Arun District Council
Development Control
Arun Civic Centre
Maltravers Road
Littlehampton
West Sussex
BN17 5LF

Our ref: HA/2022/123869/02-L01
Your ref: AB/136/21/PL
Date: 26 May 2022

UPDATED FRA - DEMOLITION OF GARAGE AND ERECTION OF TWO DWELLINGS WITH ASSOCIATED CAR PARKING AND LANDSCAPING. LAND ADJACENT 18 QUEENS LANE ARUNDEL BN18 9JN

Figure 6.1 – Showing the predicted extent of flooding and area to be lowered to offset the volume displaced.

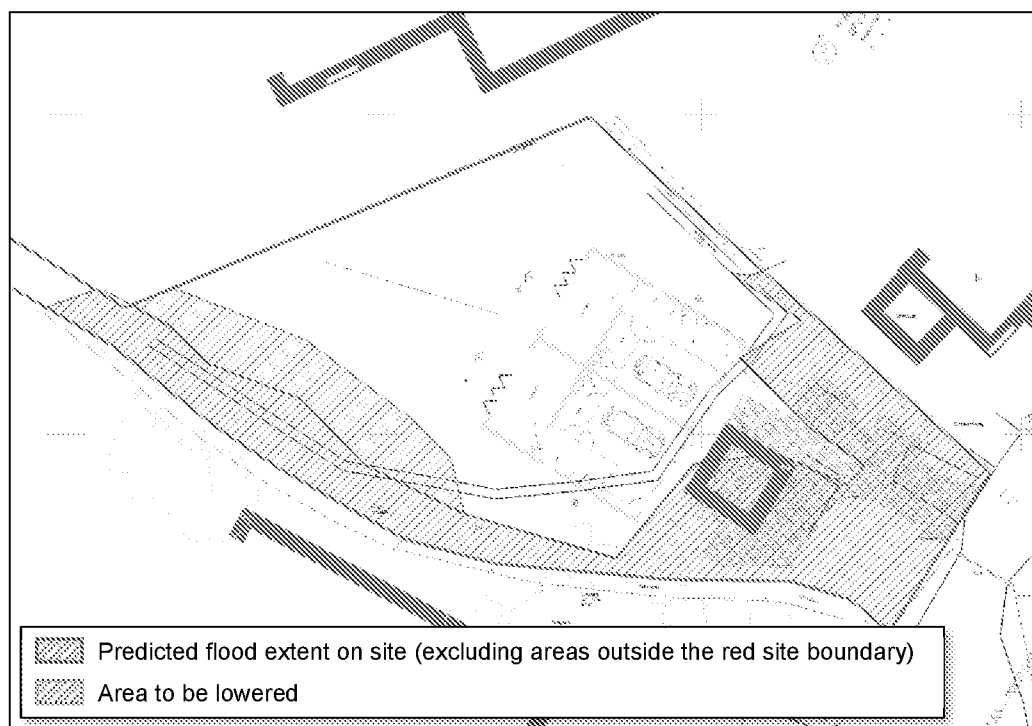
- Finished floor levels for all living and sleeping accommodation shall be set at least 300mm above the design flood level, at a minimum of 4.07m above Ordnance Datum (AOD)
- The proposed development will lower land within the rear garden, adjacent to the drainage ditch. This will ensure that the proposal will not increase the risk elsewhere as a result of floodwater being displaced by the development
